Re: 30 Merrill Street

October 4, 2016

The proposed project fails to consider the “overall context” of the neighborhood

ISSUE DATE 11/07/16
EMW
SHEET TITLE BSMNT / FIRST
SHEET SCALE 1/4" = 1'-0"

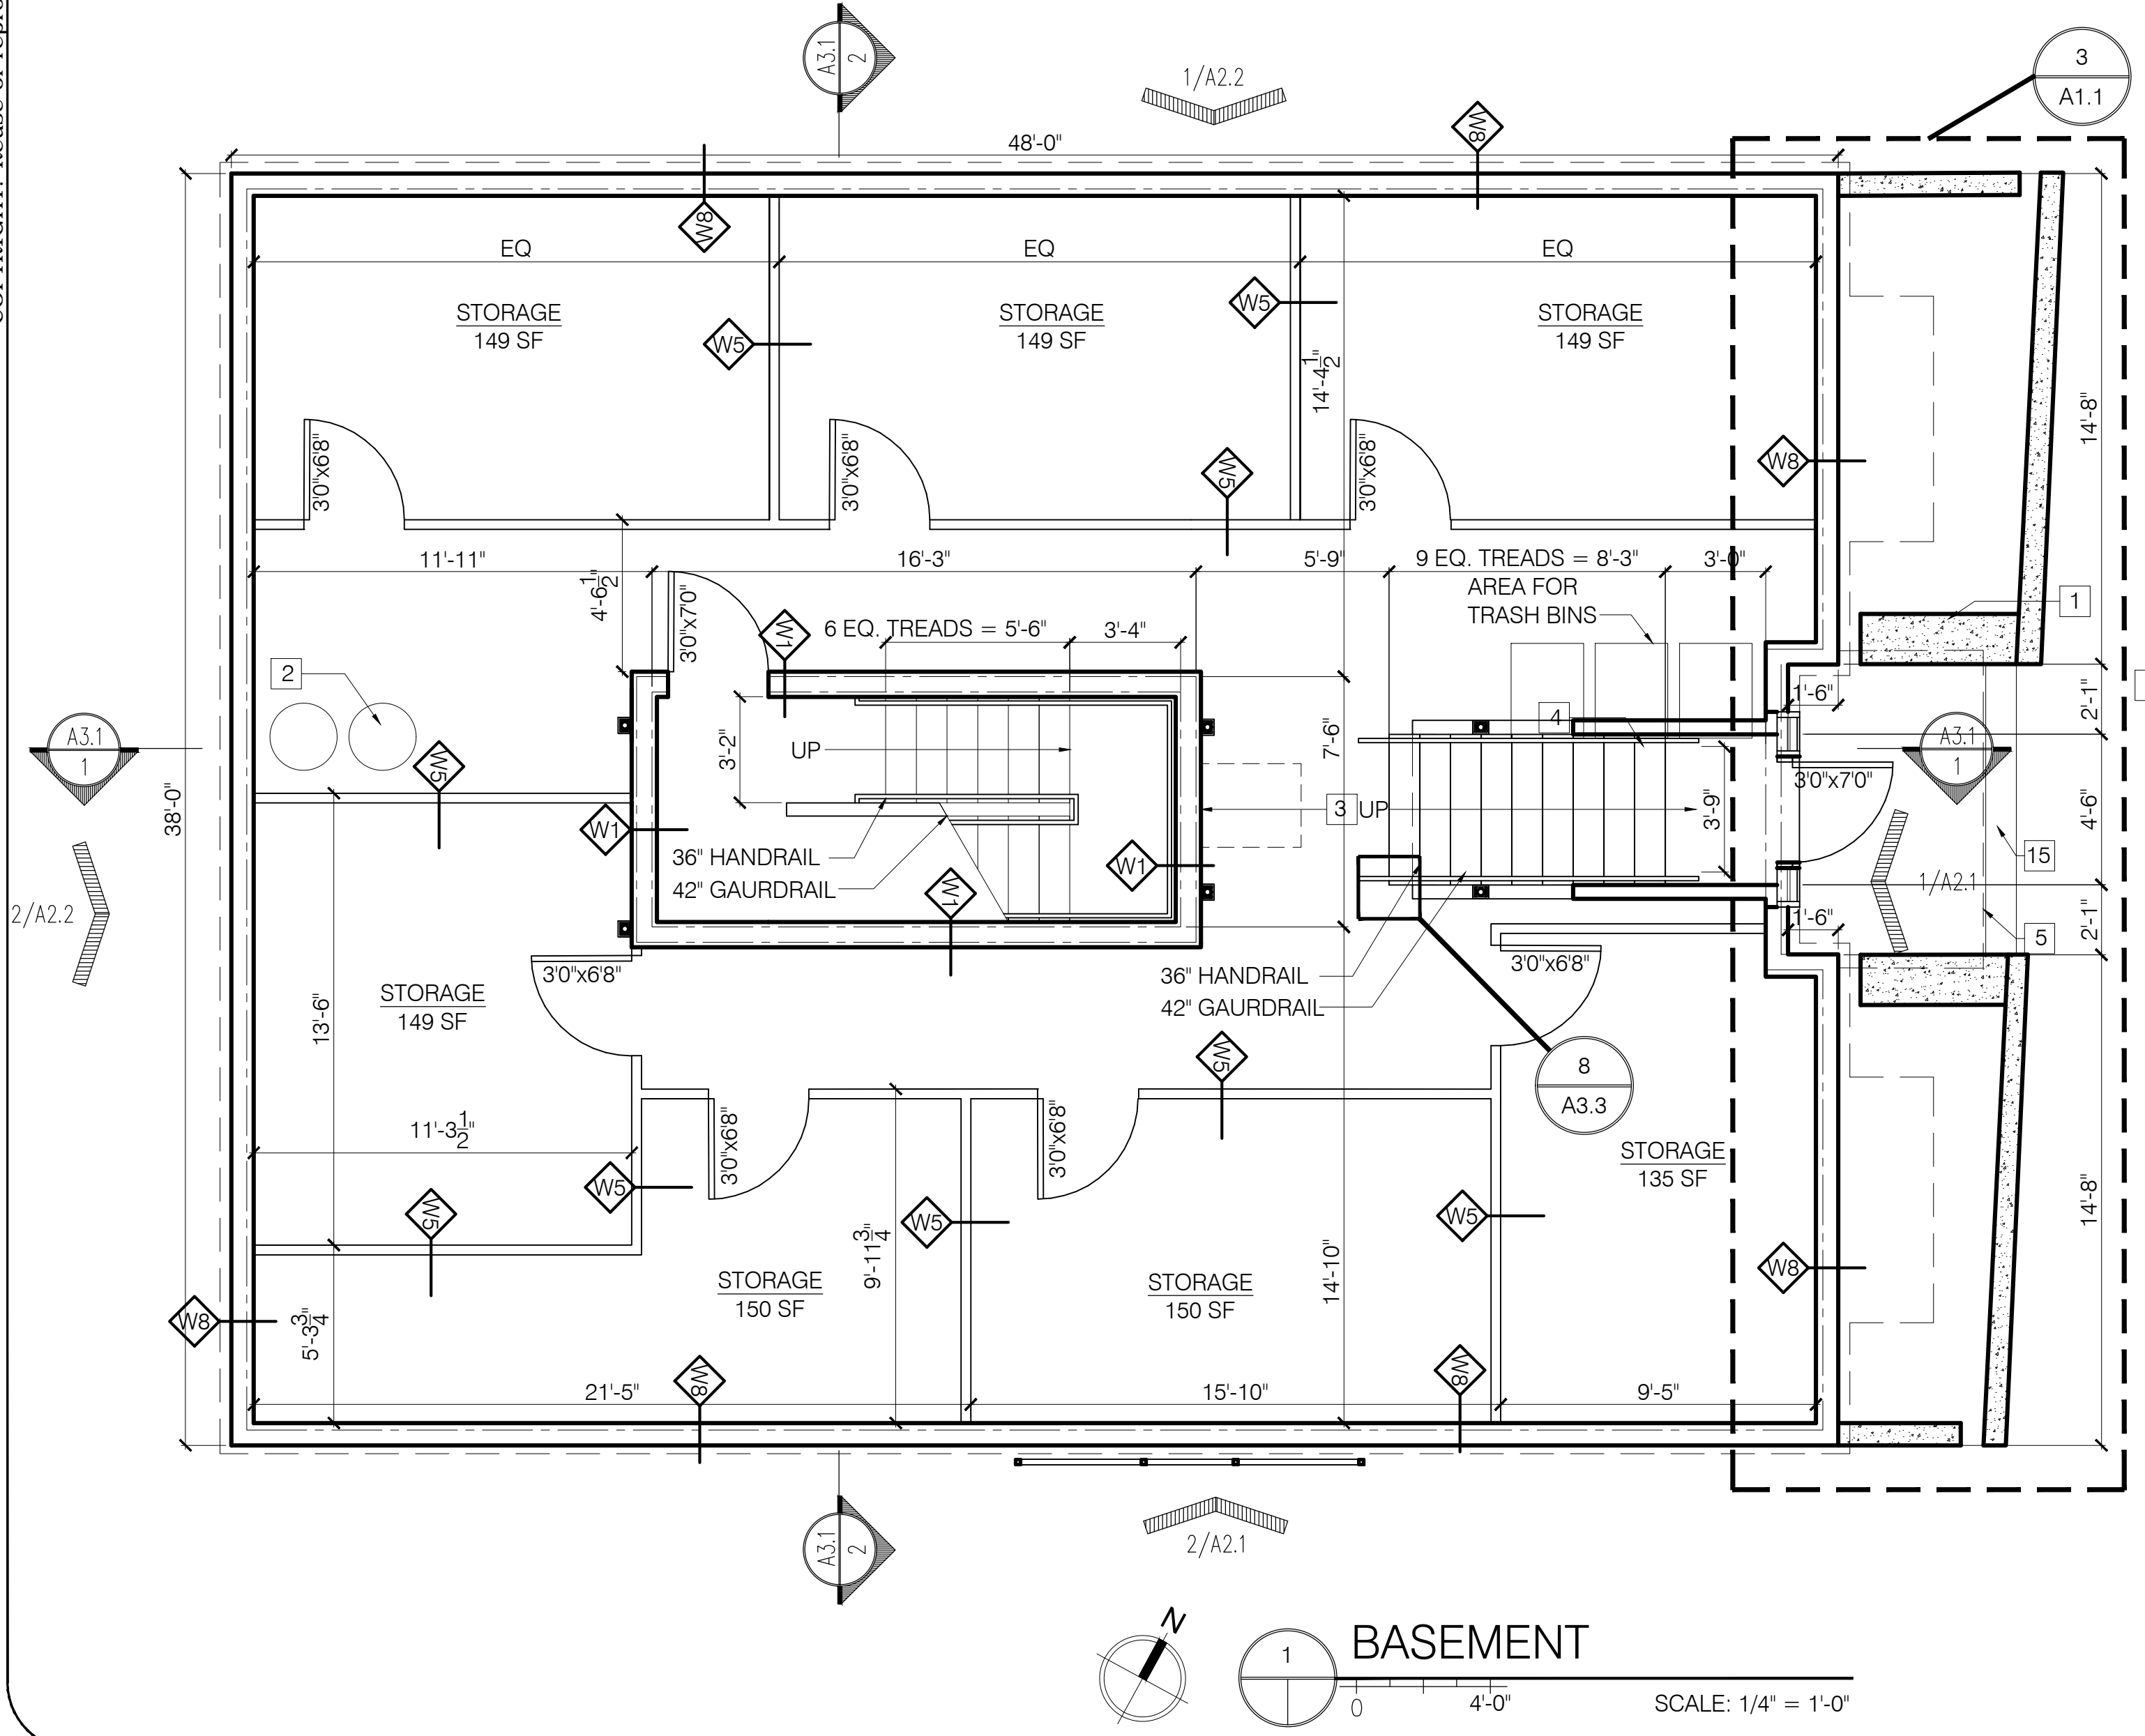
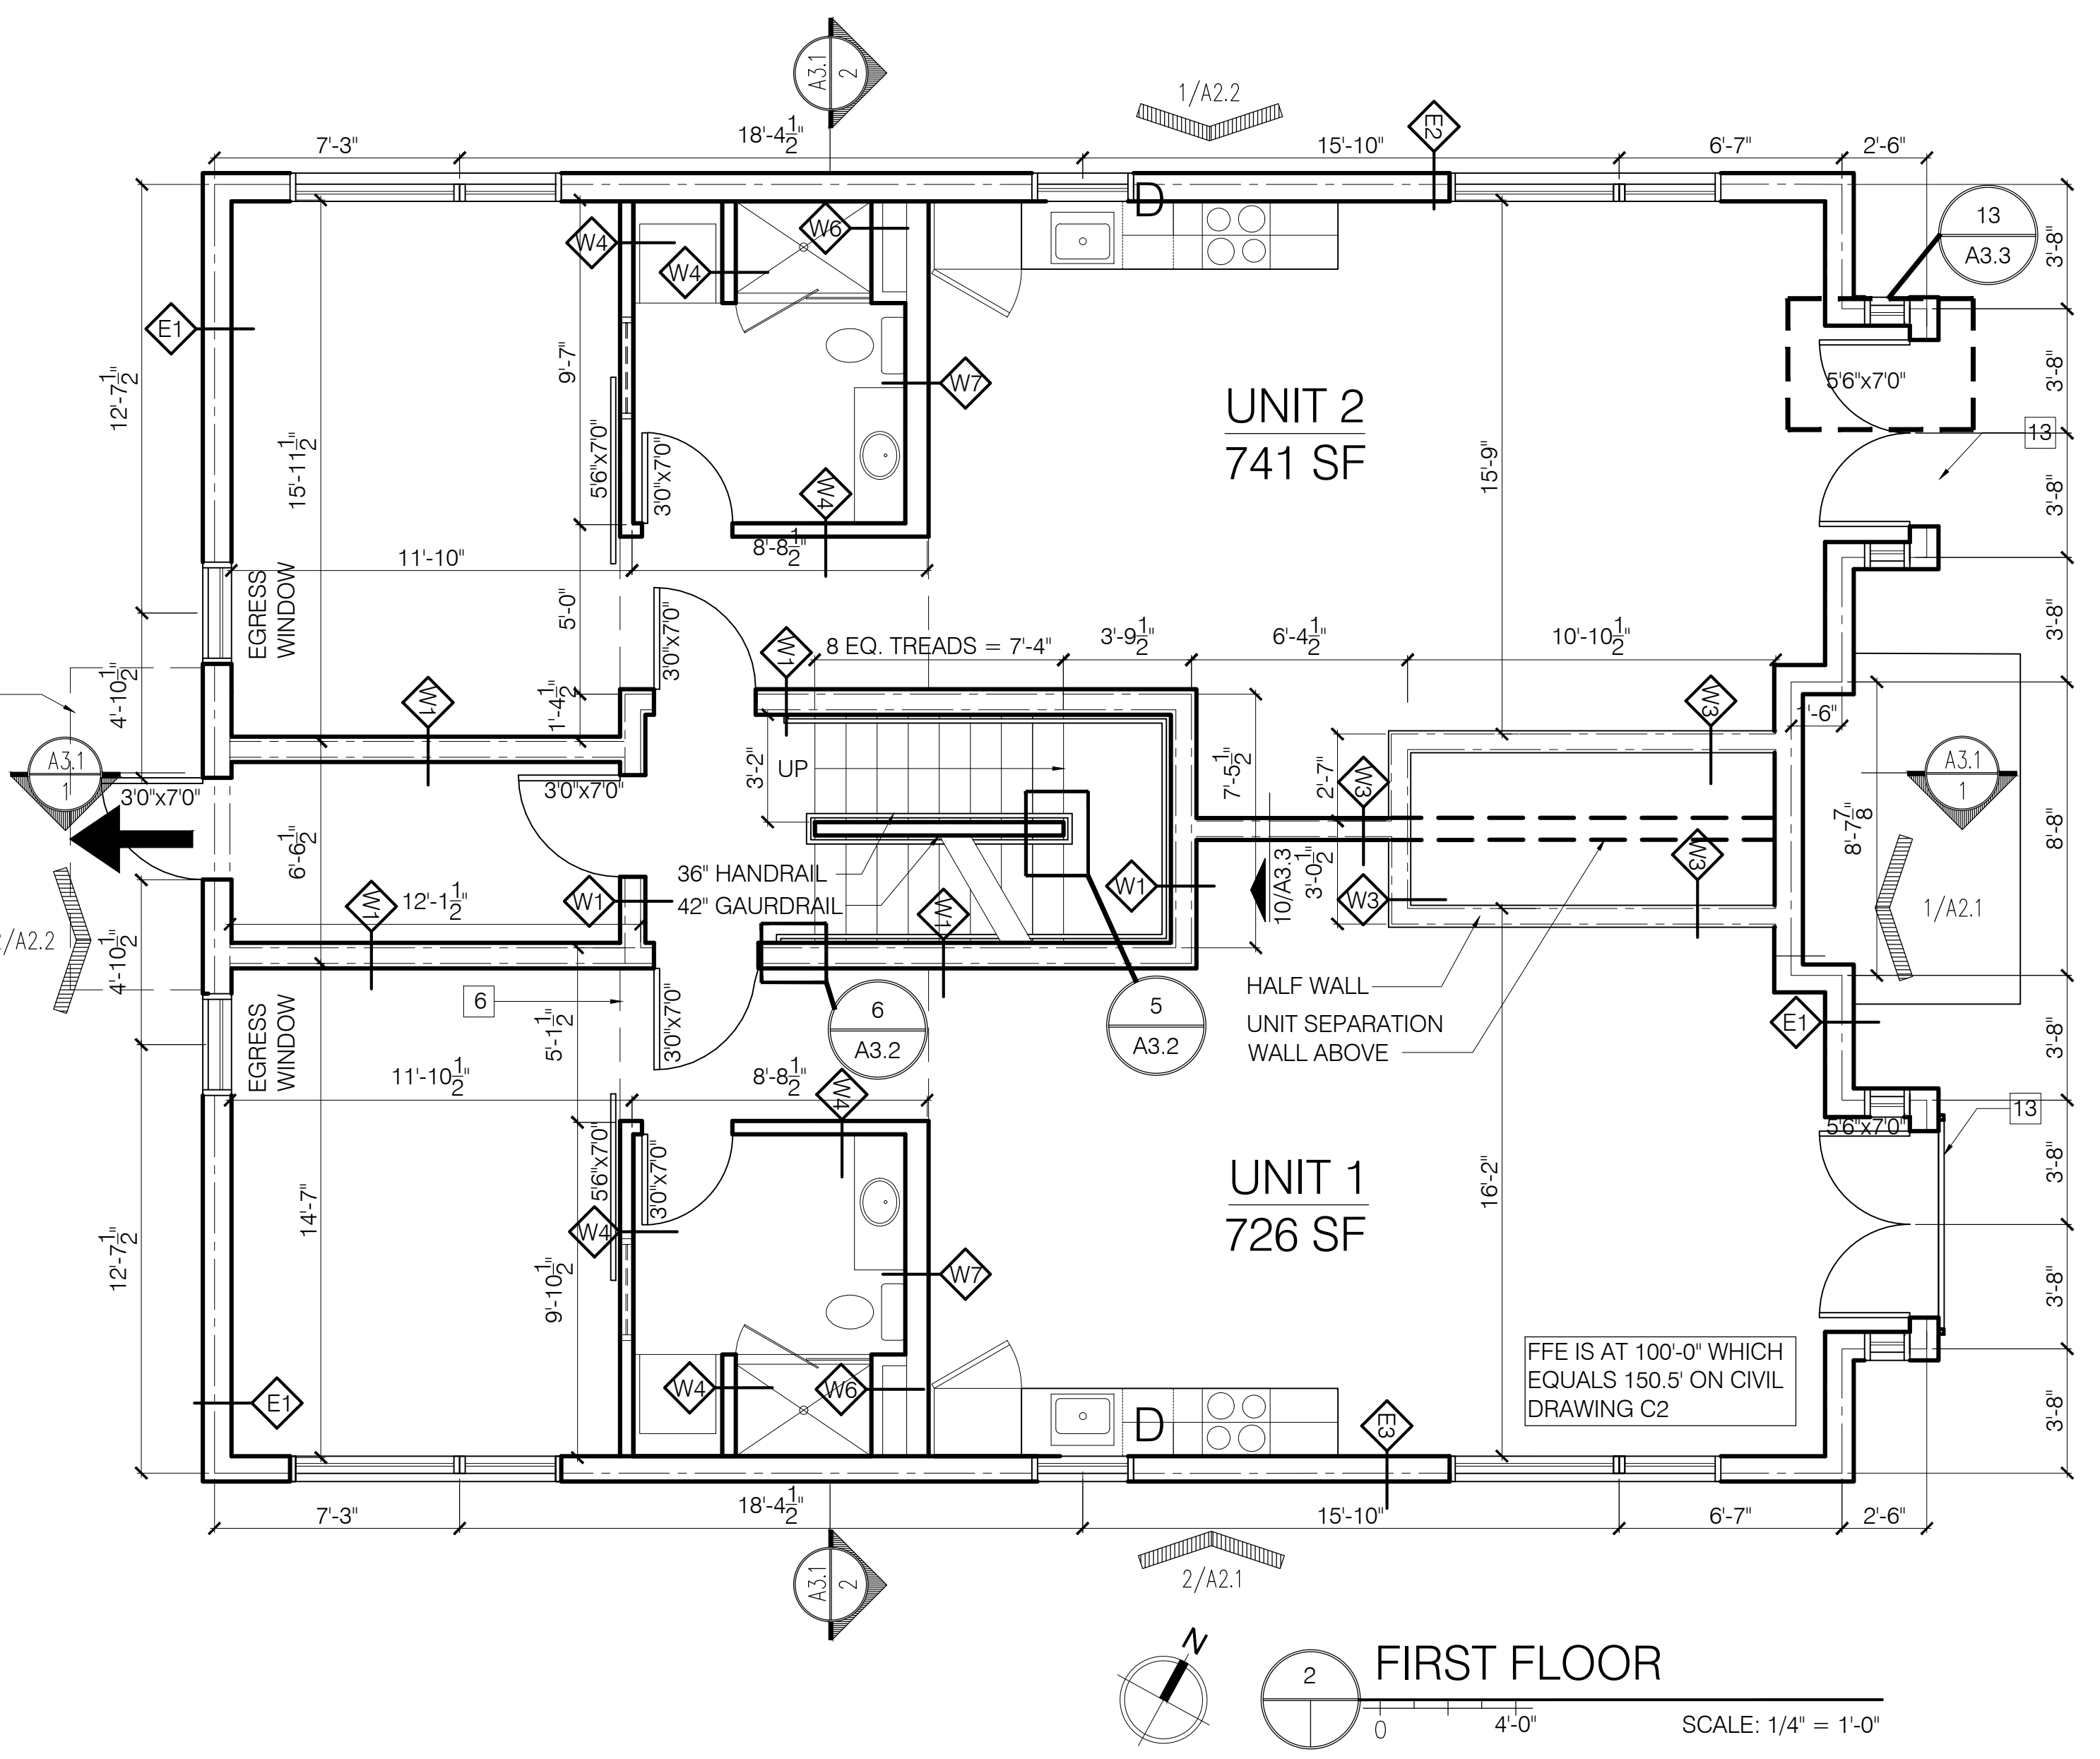
Design Standard C-1 states: "Emphasize and orient the main entrance to the street." The 30 Merrill design includes a minimally-enhanced "main entrance," which we learned at the neighborhood meeting is not a main entrance at all. In fact, it is an entrance to the basement that contains only storage areas for the units. It seems to be the argument that so long as it looks like a main entrance that is enough. It is not. There is a rationale behind this design standard that has been well articulated by numerous urban designers (Jan Gehl , Cities for Real People; Jane Jacobs, The Death and Life of Great American Cities; Christopher Alexander, A Pattern Language), planners and articulated in municipal standards. The rationales relate to the life of the street, community, walkability, and the safety of the inhabitants and passersby.

Standard C-1 requires that the main entrance either be at the front of the building or on a covered porch to the side that extends all the way to the front of the building. It makes a mockery of this design standard to interpret it to mean that something that looks like a front door is good enough. It also fails to add to the city's goal of walkability and health. Sam Newburg in his 2014 article "Front Doors and Walkable Cities" writes:

The current design cannot even attempt to pass the test of "be[ing] comfortable walking in and out of that door every day" because it is not actually a main entrance that one will walk in and out of on any regular basis. That it might be dressed up to look like a main entrance is most definitely not good enough.

There is absolutely no precedent for street level front doors in residential buildings on Merrill Street. And the examples cited by the architect are all buildings that have attractive primary entrances on the side. The street level doors on the buildings he refers to are basement doors and they look like it.
